City of Portland
 Development Review Application
 Planning Division Transmittal Form

Application Number: 2014-051 **Application Date:** 04/11/2014
CBL: 013 I025001 **Application Type:** Level III Site Plan Under 50,000 sq f
Applicant: DUGAS PETER C & ANASTASIA ANTONACOS JTS /Peter Dugas
Project Name: New 5 unit multi-family building
Address: 97 CUMBERLAND AVE
Project Description: New 5 unit multi-family building.
Zoning: R6

To: Stuart O'Brien, Chair and Members of the Portland Planning Board
From: Jean Fraser, Planner
Date: May 23rd, 2014
Re: **May 27th, 2014 Planning Board Workshop**
 Level III Site Plan and Subdivision Review
 5-unit multi-family building
 97 Cumberland Avenue
 Peter Dugas, Applicant

TO: Jean Fraser, Planner
FROM: David Senus, P.E.
DATE: May 5, 2014
RE: 97 Cumberland Ave Multi-family, Level III Site Plan Application

Drawing file: Original submissions 4.11.2014 / A1.2 Preliminary Site Plan.pdf

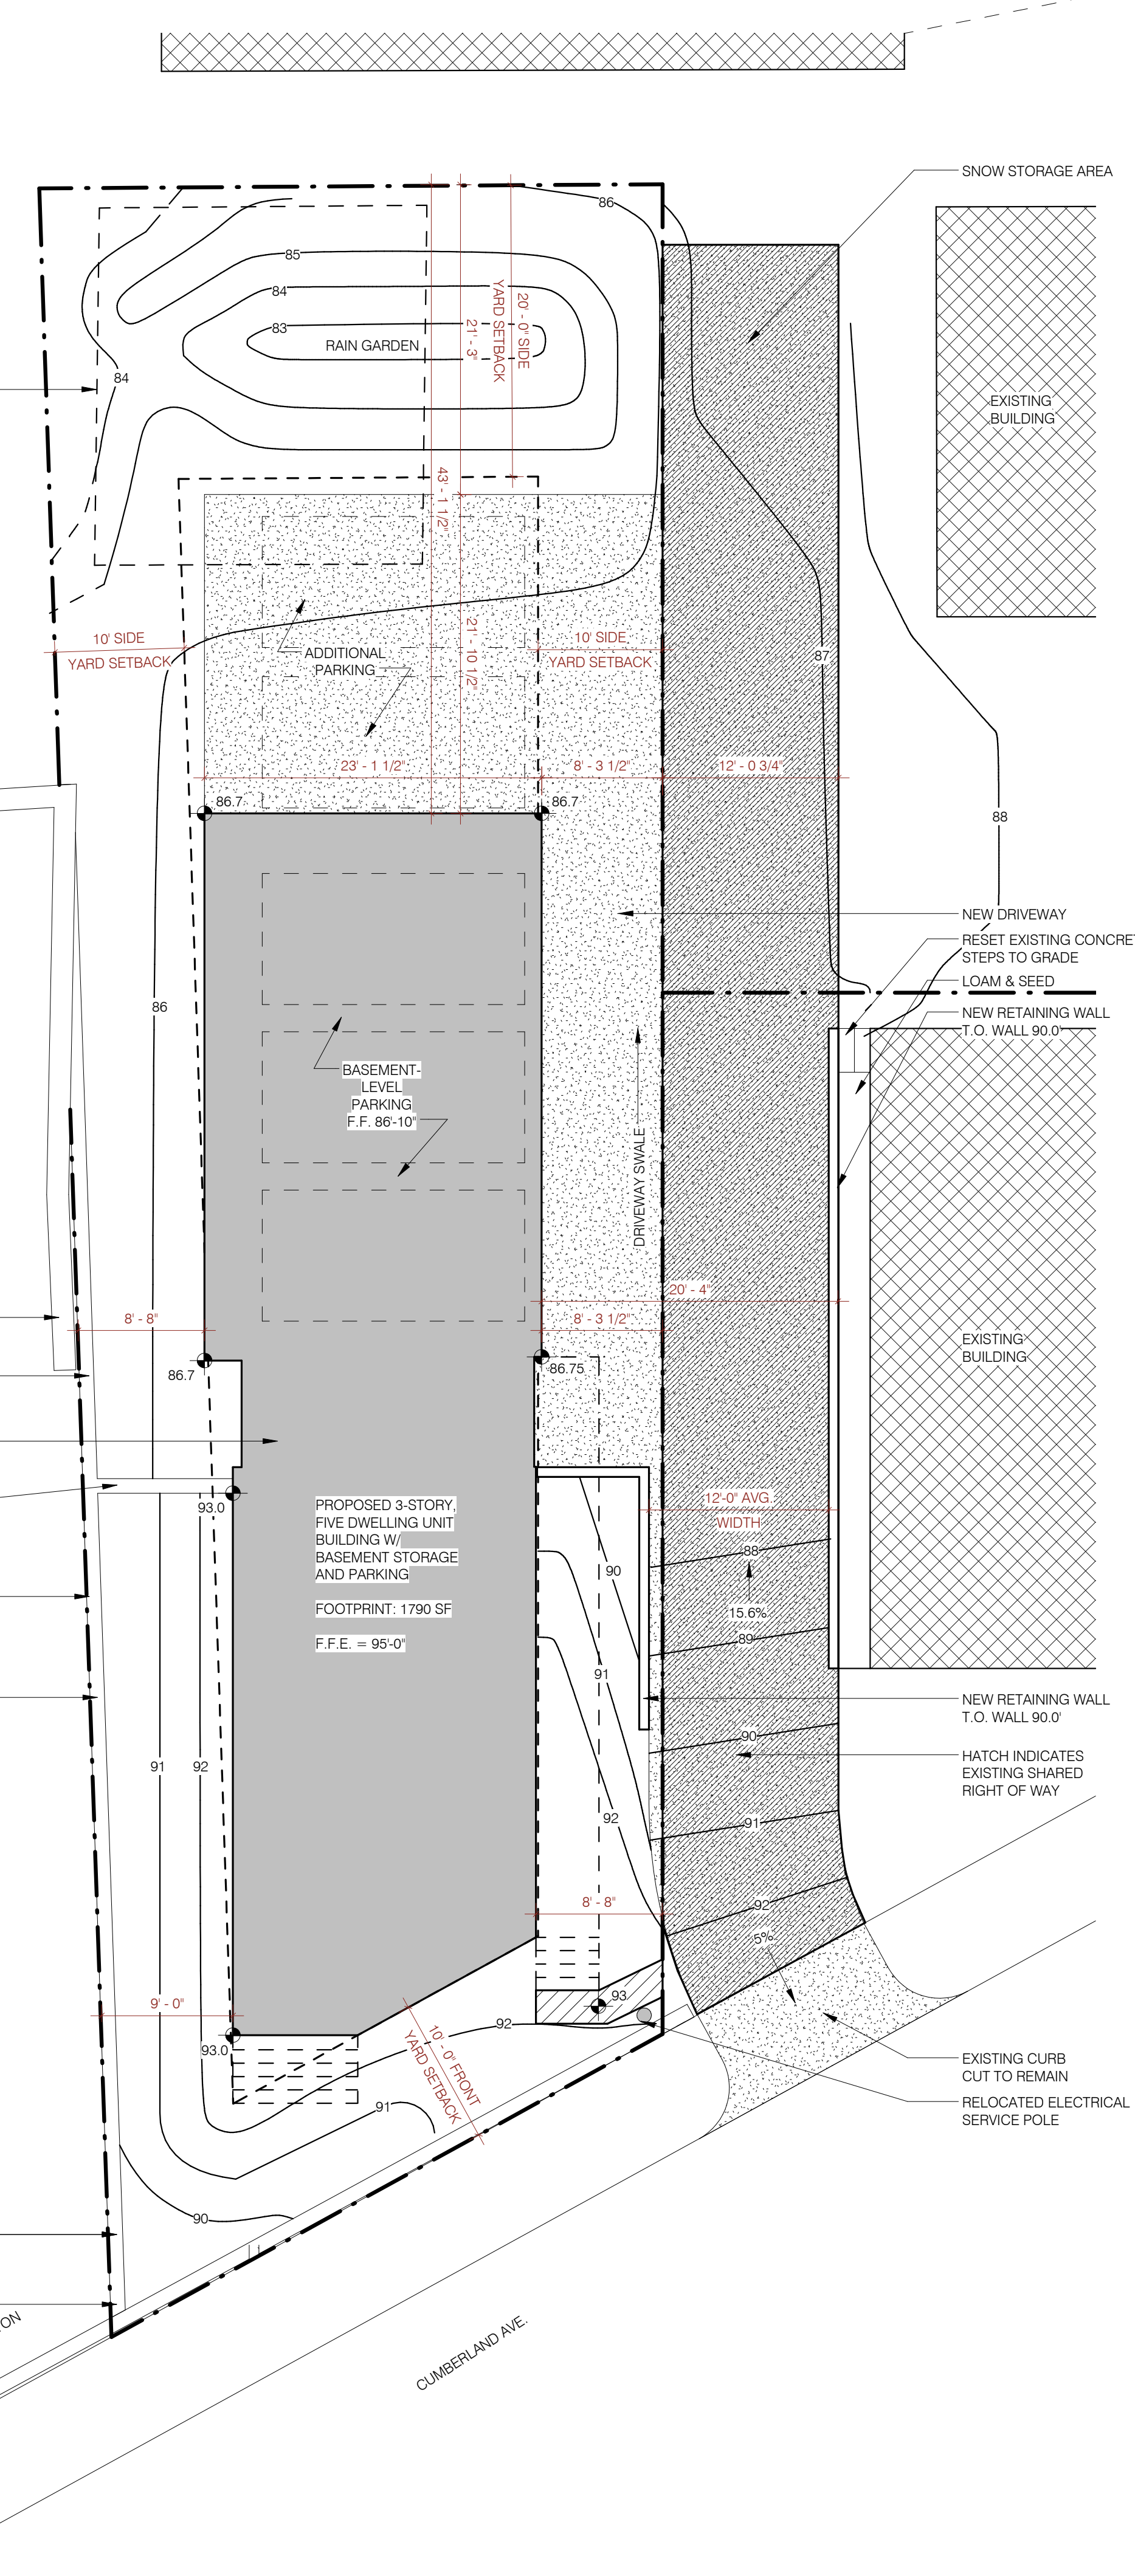
I have reviewed this project for a new 5 unit residential 3-story structure. My major concern after this review is the required 10' side setback for the building. Both sides are not meeting the required minimum 10' setback. I am uncertain why the applicant is showing that there is less than the required 10' side yard setback when the document acknowledges the 10' required. All other R-6 dimensional requirements are being met.

The proposed access utilizes the existing driveway that serves the three lots. Its effective width is proposed to be narrowed to 12 feet (see Plan P2) which is considered acceptable in terms of a driveway but may preclude parking in the driveway by users who have rights to that area.

The Site Plan shows snow storage within the abutters lot (rear part of 93 Cumberland Avenue) and as noted by Tom Errico (Attachment 2) this may also interfere with other users of the Right of Way drive access. The applicant is requested to confirm that he has rights to place snow at this location.

Drawing file: Original submissions 4.11.2014 / C1.2 Engineer Site Plan.PDF

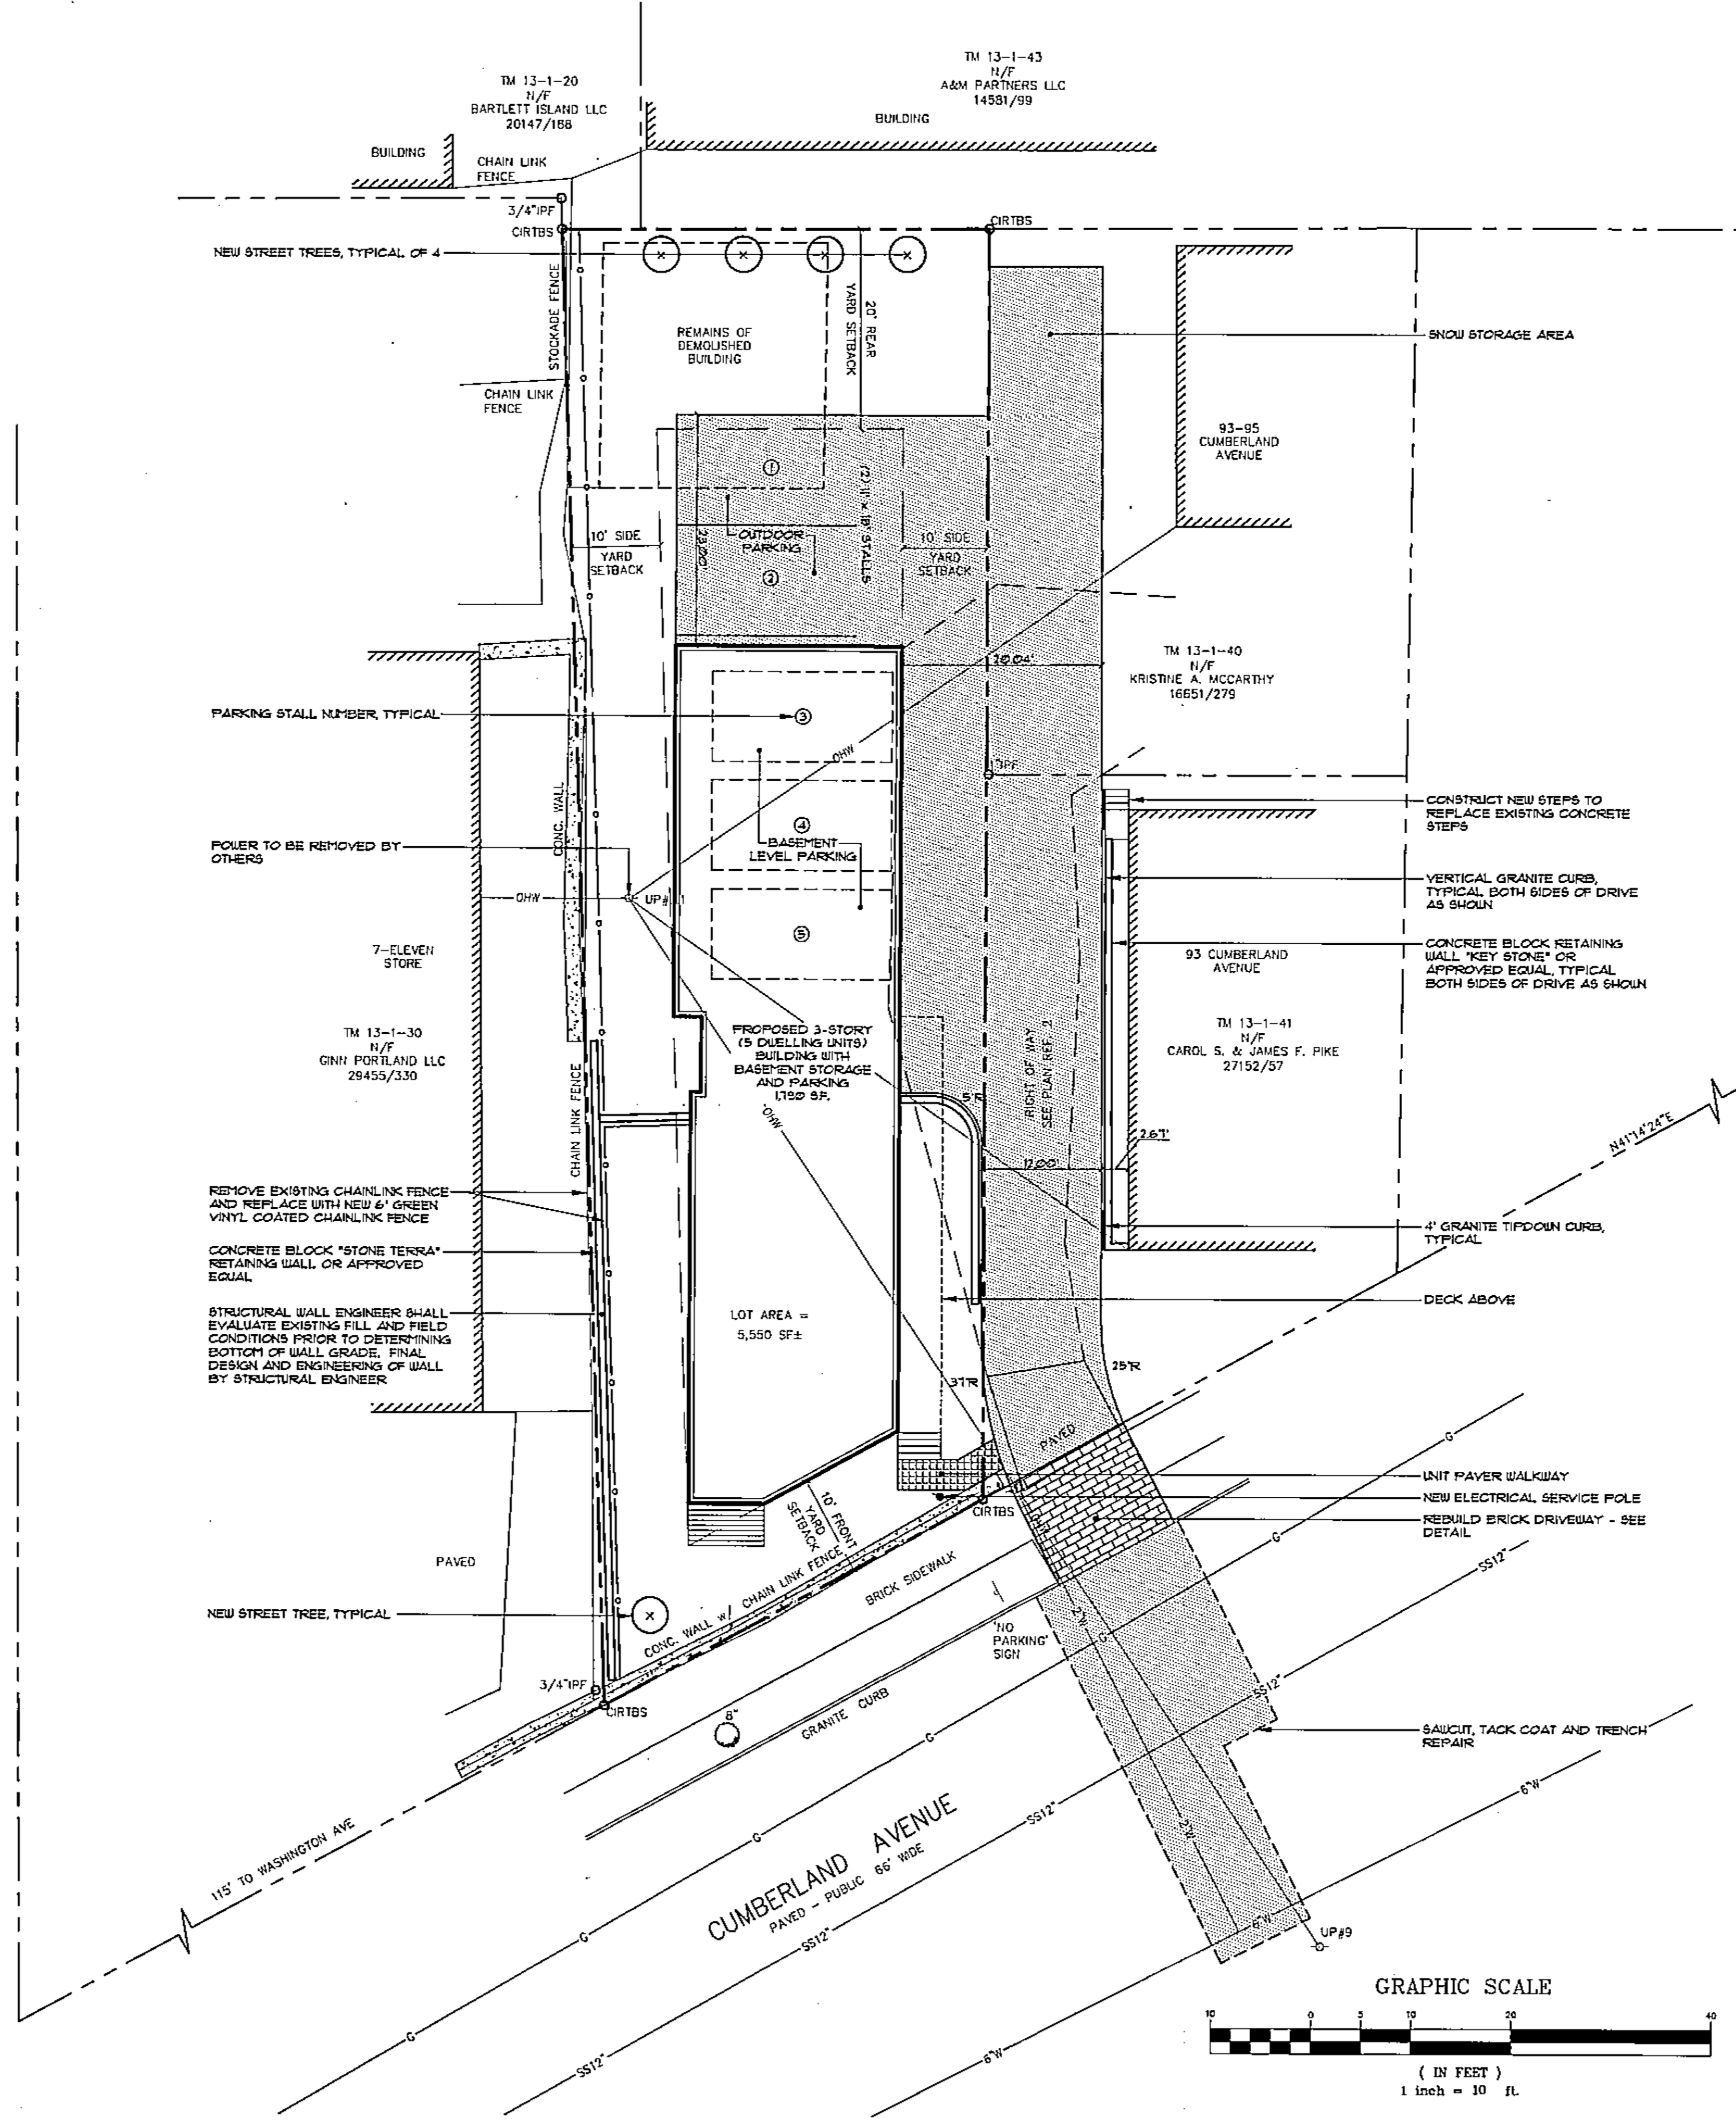
- 6) The Applicant proposes a rip-rap spillway to manage overflow from the proposed infiltration basin. Overflow from this spillway will drain west, below a stockade fence, across a fenced dumpster area on the 7-Eleven property, and across the 7-Eleven parking lot to the Washington Avenue drainage collection system. The applicant notes that this route is similar to the pre-development drainage pattern (existing condition); however, a review of the HydroCAD model indicates that more area will be directed to this location in the post-development condition, and although the infiltration basin will provide minor detention, the model predicts an increase in runoff rate at this location (from the spillway) in the post-development 10- and 25-year storm events. The drainage design should be revisited to eliminate directing overflow onto the neighboring property, unless the Applicant obtains drainage easements from N/F Ginn Portland LLC and modifies the adjacent fence and dumpster/parking area to accommodate drainage from the site. The Applicant should propose an alternative means of managing overflows from the infiltration basin.

- 7) How will roof drainage be managed from the proposed building?
 - 8) The existing site includes a utility pole that provides overhead service (presumably both electrical and telecommunications) to buildings on three adjacent properties. The plan calls for eliminating this pole and the associated existing overhead services; however, it does not address how new services will be provided to all adjacent properties, specifically the 7-Eleven store.

- 9) The Grading and Utility Plan (Sheet 3 of 5) proposes grading well onto the lot that is N/F Kristine McCarthy (93-95 Cumberland); however, no finish surface is specified and it is unclear if the Applicant has rights to perform this work.

BRICK WITH BITUMINOUS BASE DRIVEWAY CONSTRUCTION
NOT TO SCALE

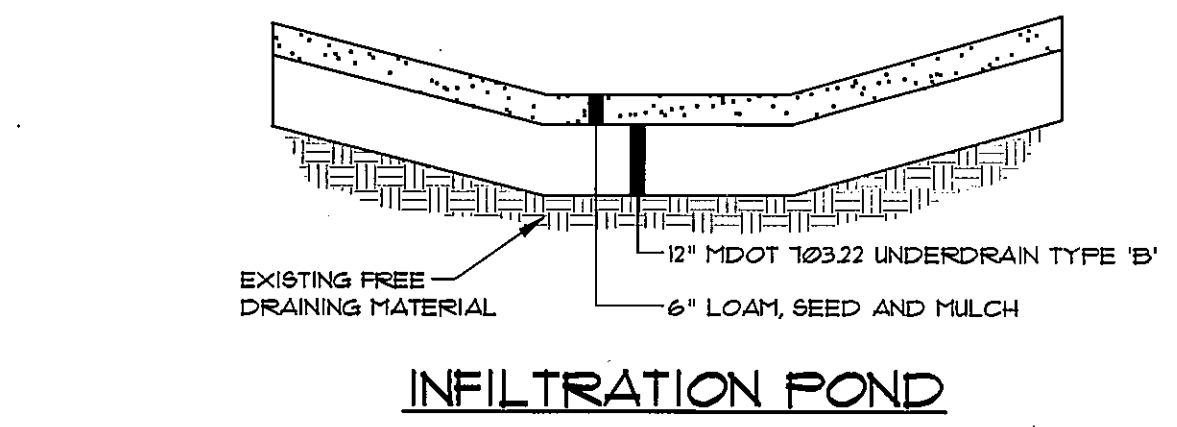
* The driveway apron is proposed to be brick. This does not meet City standards for non-historic districts on the peninsula. DPS will be reviewing this issue.
